Please find below Councils response in relation to the latest JBA response to Councils email and the meeting held at Council offices on 8 February 2017.

***Amendments to roof and building plant (1.1)**

It is acknowledged that the additional building plant level is setback from the 30m wide zone subject of the building height standard in the Randwick Local Environmental Plan (LEP) 2012 (ref Grid 2 height of buildings map in www.legislation.nsw.gov.au).

Fig. 5 - Proposed Amended Building Form (Aerial view from northwest)

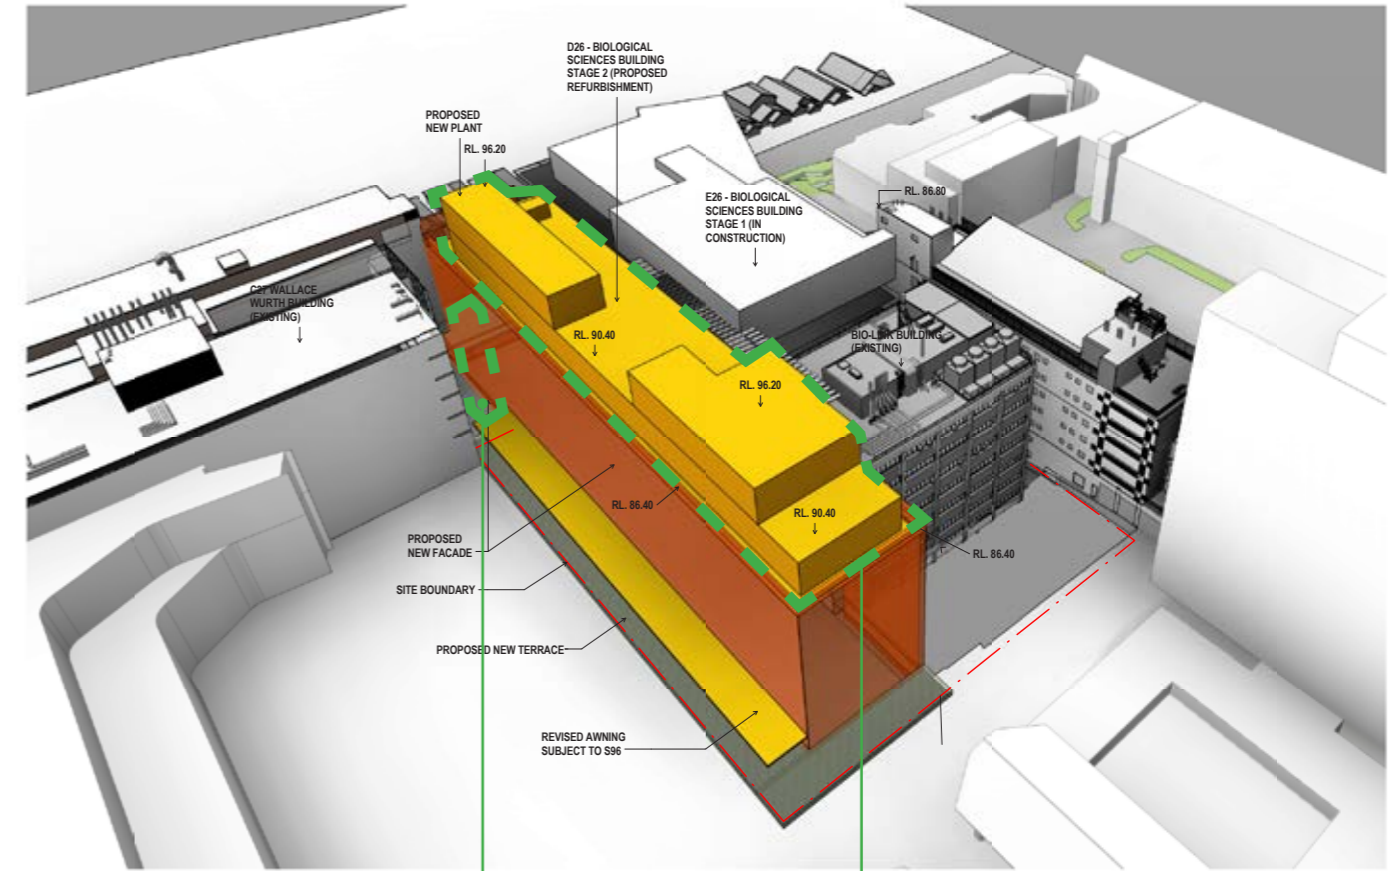
As indicated in the RDCP, Current campus buildings present a range of quality, forms, architectural styles and functions. Some contribute to the existing sense of place and/or are of architectural significance. All buildings on campus should excel in terms of ... their urban design role in the campus structure and form, architectural quality. The height of the additional plant as viewed from the public domain along both Botany Street and High Street will not be highly visible directly adjacent to the premises however when viewed from the wider public domain it may potentially be incompatible with the adjoining built forms in relation to scale and profile. As previously advised, it is suggested that an innovative design solution be investigated that would improve its aesthetic appearance to ensure the overall development contributes to the streetscape character.
